Our ref: RA/2019/139720/01-L01
Your ref: 2018/92593
Date: 18 February 2019

PROPOSAL: ALTERATIONS TO CONVERT FORMER MILL INTO 20 APARTMENTS AND CHANGE OF USE OF NIGHTCLUB (SUI GENERIS) INTO A WINE BAR (A4) (WITHIN A CONSERVATION AREA)

LOCATION: JESSOPS MILL, STATION ROAD, BATLEY, WF17 5SU

EXISTING SITE PLAN / ROOF PLAN

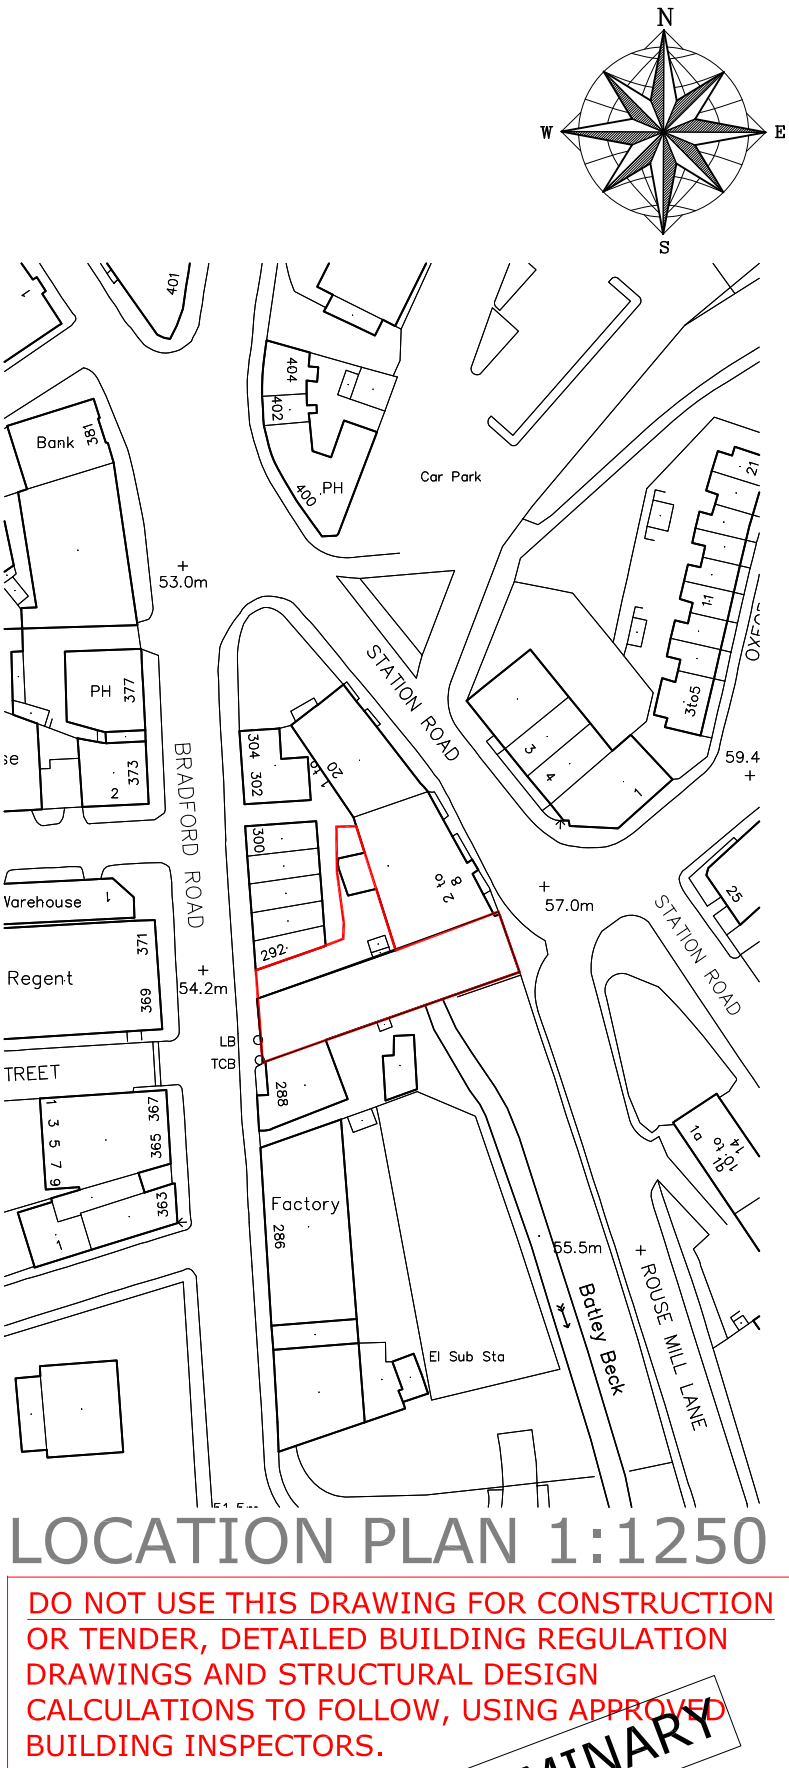
- 1) The application submitted does not include a red line boundary plan therefore the advice we are providing is not definitive on the flood risk. A clear red line boundary plan must be provided so we can identify the extent of the site and the flood risk as this changes across the site.

It is not clear from the elevations provided what the layout plan for the site is, if this can be provided showing the existing and proposed buildings.

DRG:
PROPOSED SECTION

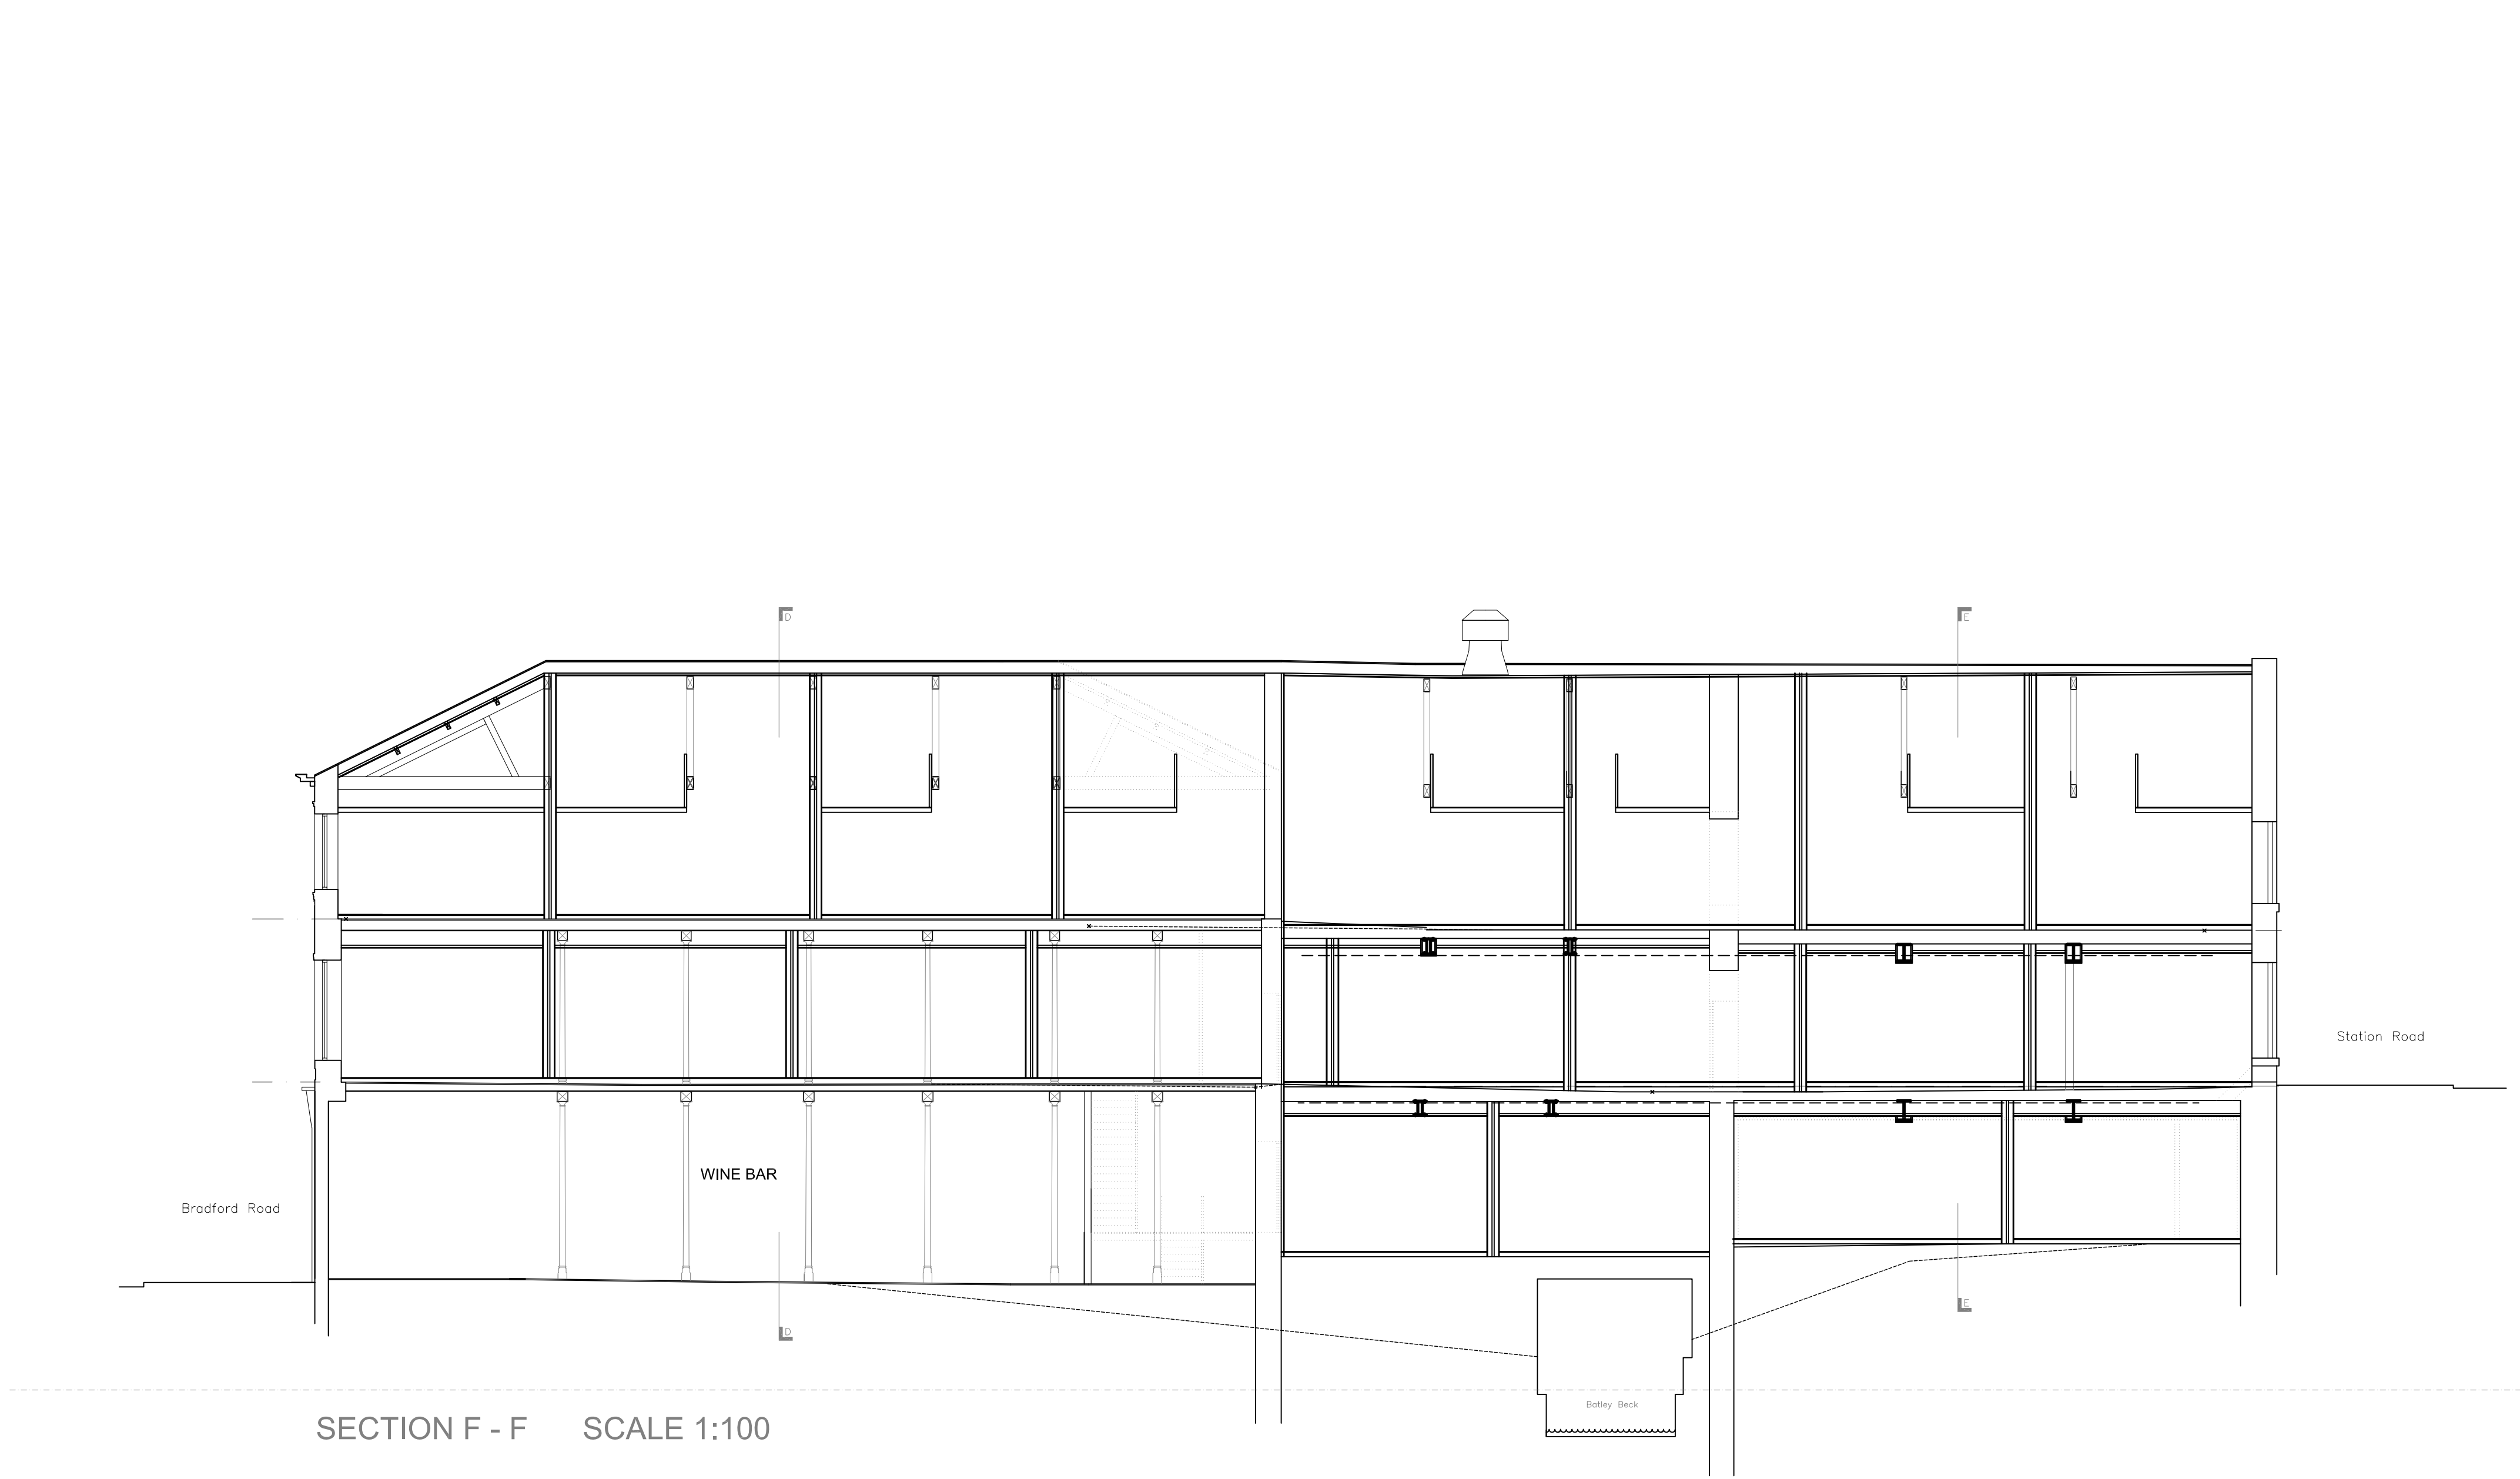
The plans show more vulnerable self-contained residential flats and drinking establishment uses in the lower ground floor.

It is not clear whether the lower ground floor falls within the classification of a basement from Building Regs Approved Document B – “A storey with a floor which at some point is more than 1200mm below the highest level of ground adjacent to the outside walls”. Can you please confirm this.

We do not expect to see more vulnerable self-contained flats or drinking establishments within basements or lower ground floor areas. Habitable uses of basements within flood affected areas should not be permitted due to the potential dangers to life during a flood event. The basement must have unimpeded access and be of waterproof construction to avoid seepage during flooding conditions. Habitable uses of basements within flood affected areas should not be permitted due to the potential dangers to life during a flood event”.
